ATTACHMENT 1

In order to finalise the Department's assessment, additional information is required including but not limited to the following:

Figure 2.1. Swept paths for heavy vehicles accessing the site at 14- 16 Kiora Crescent, Yennora. NSW Surveys PTY LTD, 8/11/19.

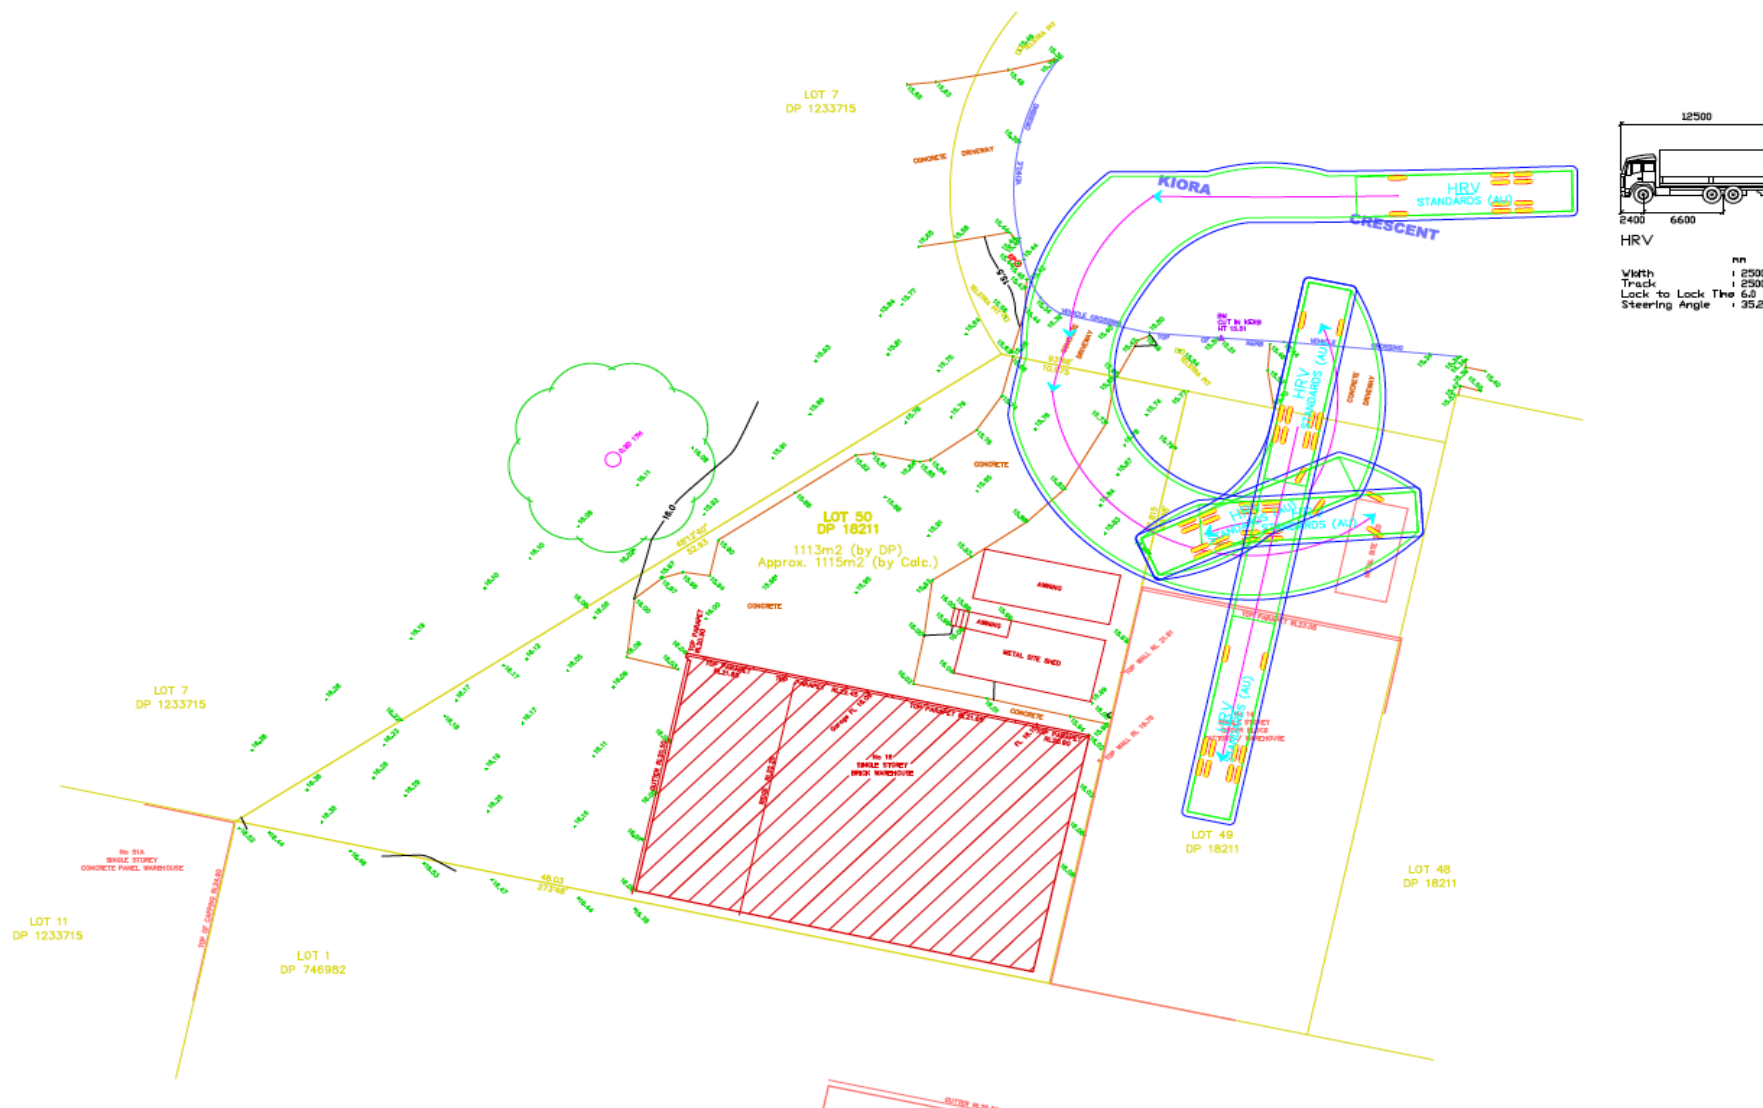
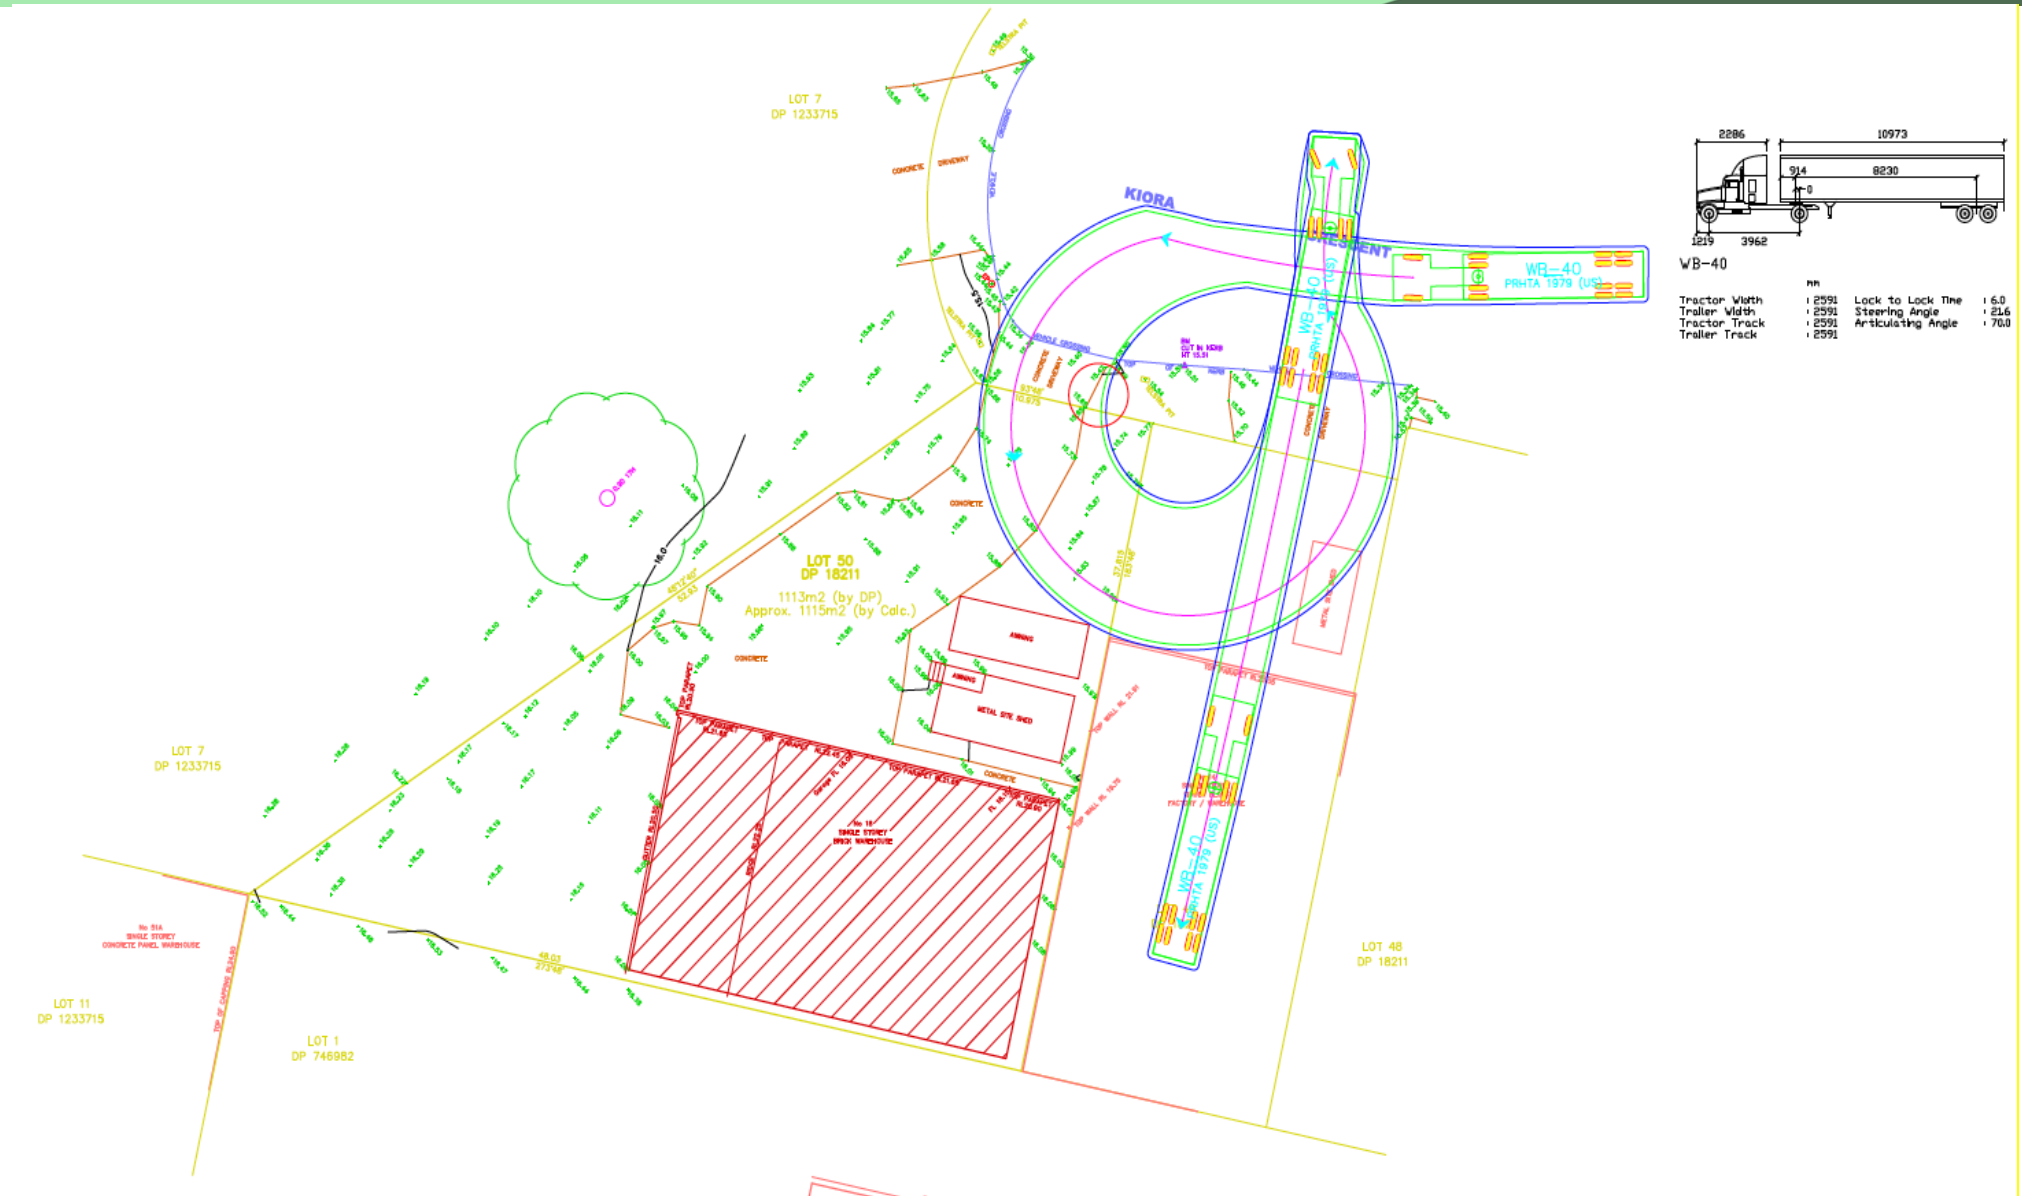
- Previous advice provided by the Department and Council to the Applicant has outlined that the internal swept path movements are not appropriate and need to be updated to demonstrate that turning paths would not encroach onto Council footpath, nature strip or any other infrastructure located on Council land. It is noted that the advice has not been considered in the EIS, it is required that mitigation measures and/or alternatives need to be considered and subsequently updated to meet Council and the Department's requirements.

- The manoeuvring and turning of the vehicle must be completed within the site and must not cause encroachment into nature strip or the footpath. The swept path diagrams demonstrate otherwise with the encroachment into nature strip. As per previous correspondence the Department requested the proponent consult with Council to resolve internal swept path movements satisfactorily. Please provide further evidence of any further consultation with Council regarding the outcome and resolution of these issues.
